Ribble Valley Borough Council
Housing & Development Control

Application no: **3/2023/0591**

Address: **9 Hereford Drive Clitheroe BB7 1JP**

Proposal: **Proposed single-storey extension to rear, pitched roof over front porch and side garage and demolition of rear conservatory.**

PROPOSED SITE PLAN

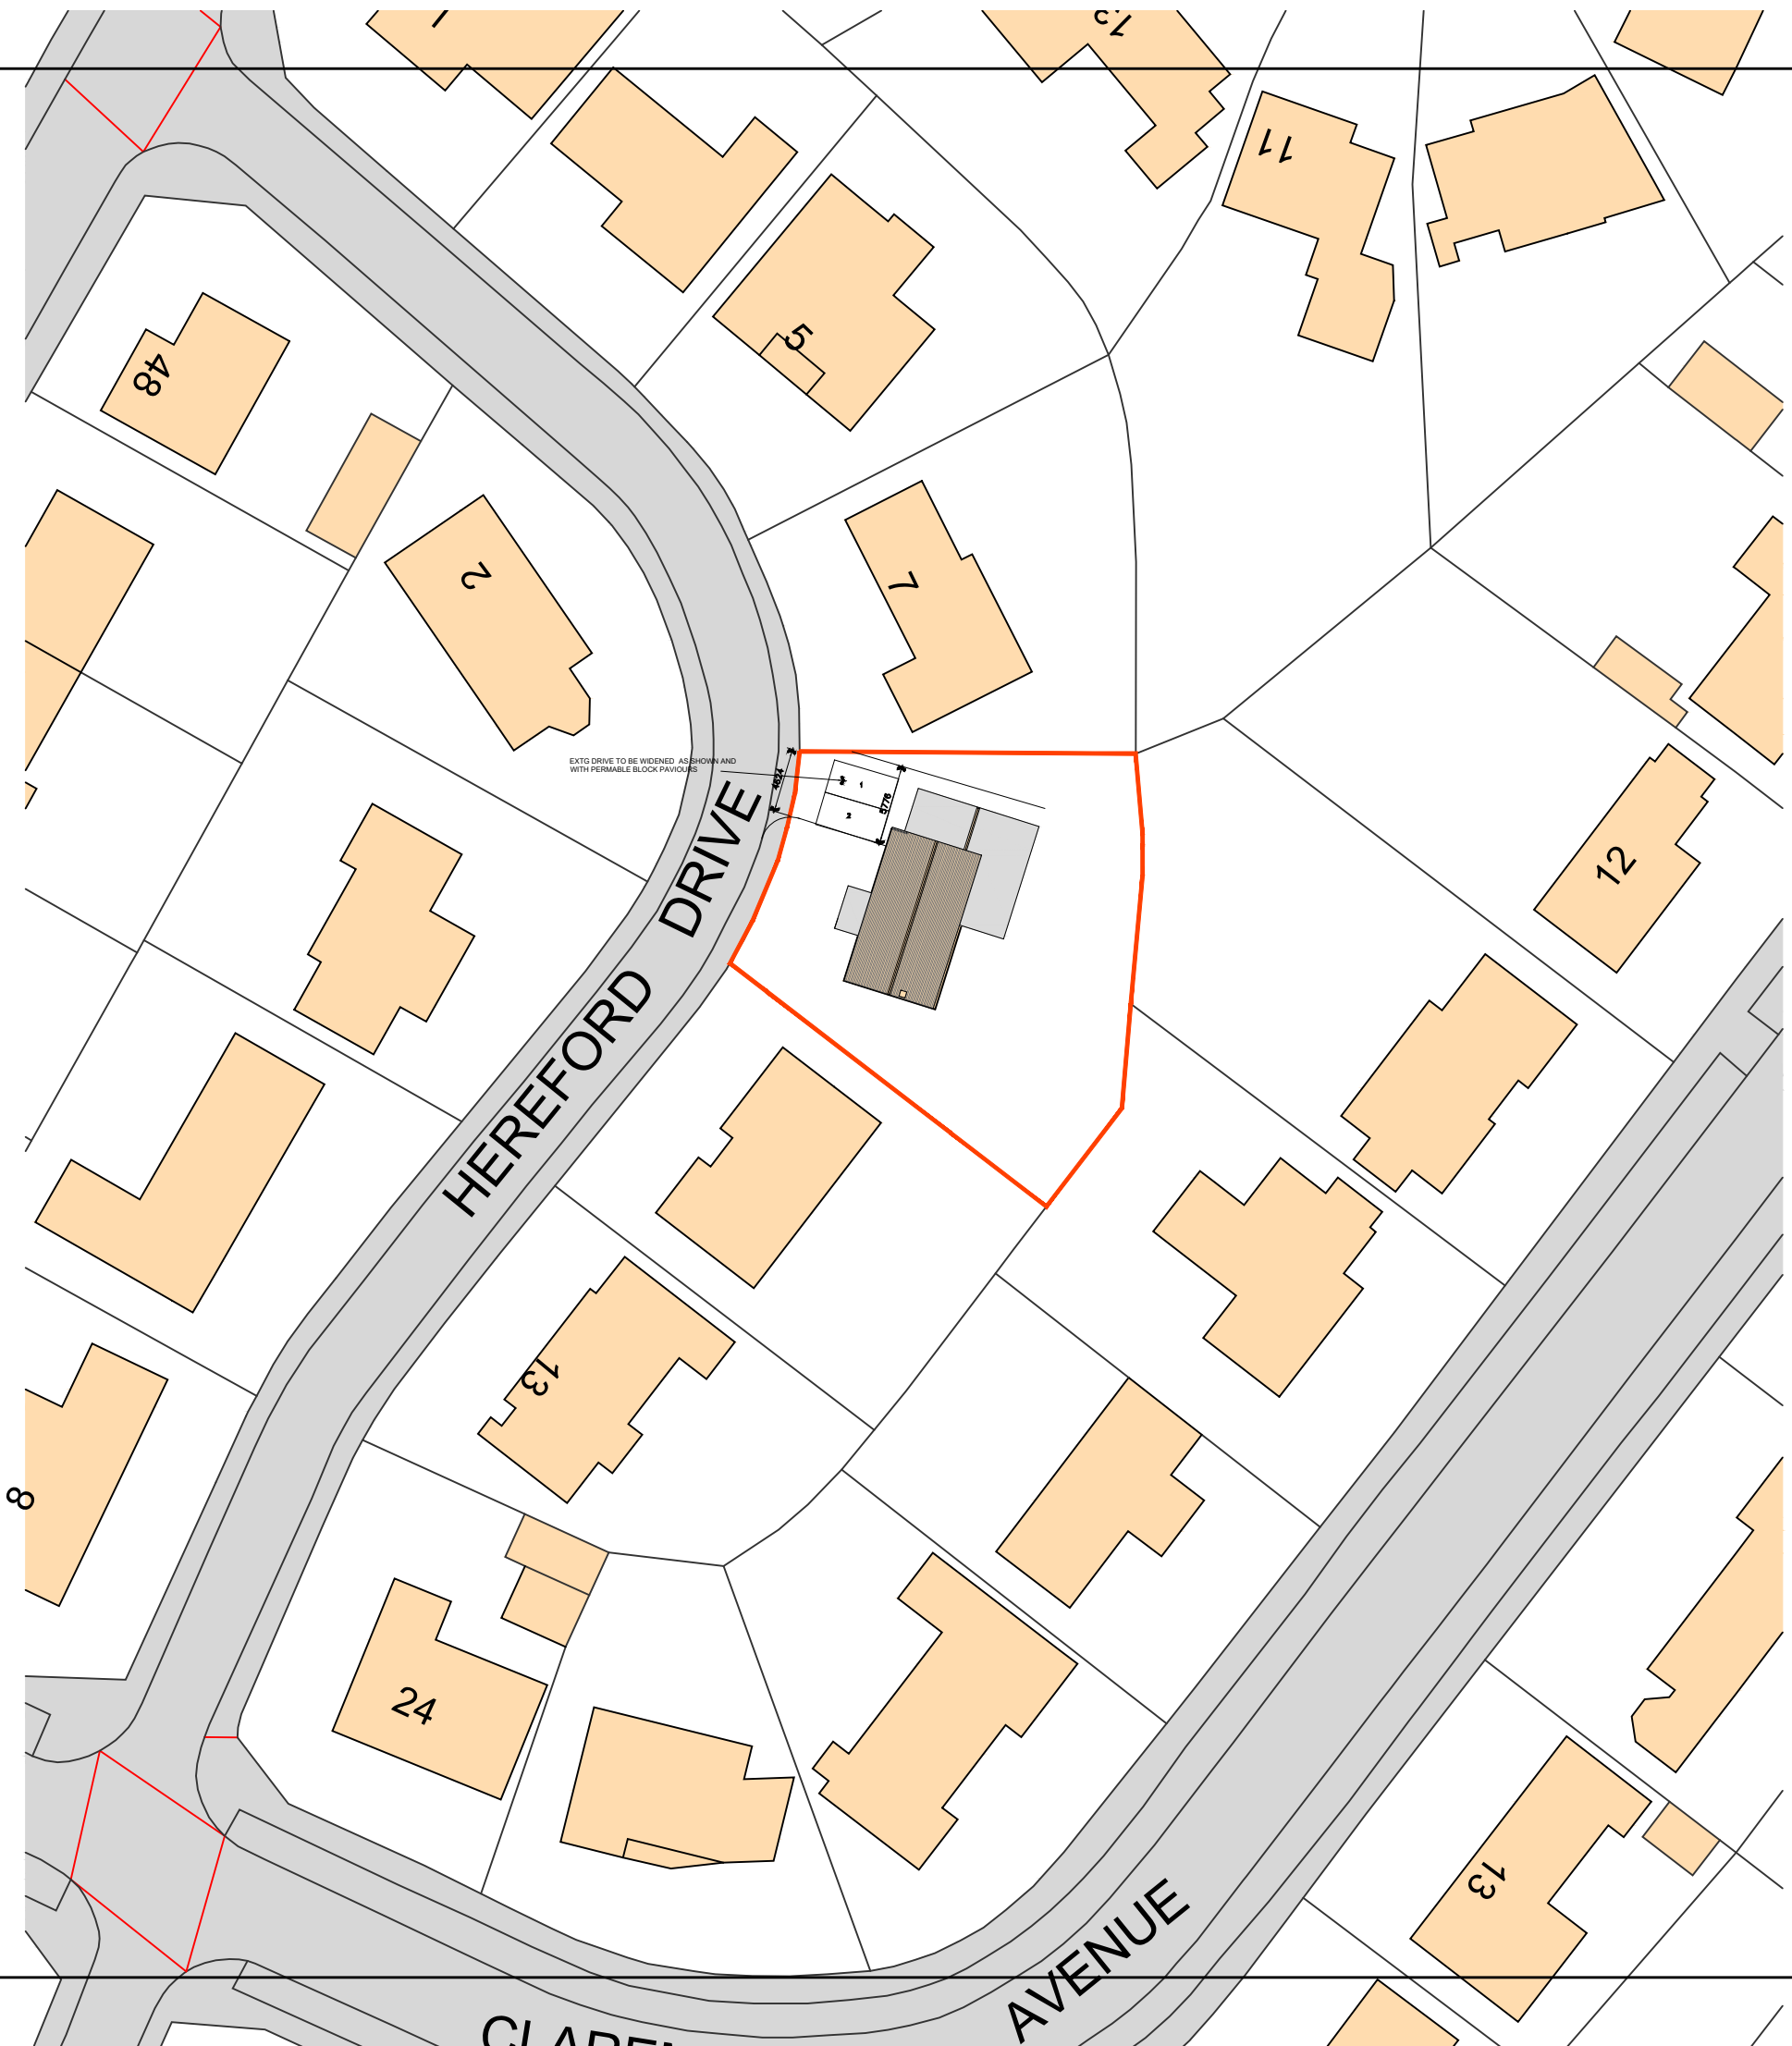
In response to this, the Agent has provided A.L.H drawing number 06B titled "Proposed Site Plan" which shows that the site can provide 3 car parking spaces on the existing driveway to comply with the LHAs parking guidance as defined in the Joint Lancashire Structure Plan.

However, the LHA are unable to formalise this area for three car parking spaces with it being unacceptable given that two of the spaces will be unusable and internal conflicts may occur should all three spaces be used. Therefore, as a result, the LHA will request that following the change in the parking arrangements at the site following the omission of the garage, the LHA will request that the access and the driveway is extended to provide an additional car parking space. This should be shown on a revised drawing.

The LHA require an amended drawing is submitted showing that the access and the driveway is extended to incorporate an additional car parking space. Should a revised drawing be submitted showing what has been requested, the LHA will have no objection to the proposal.
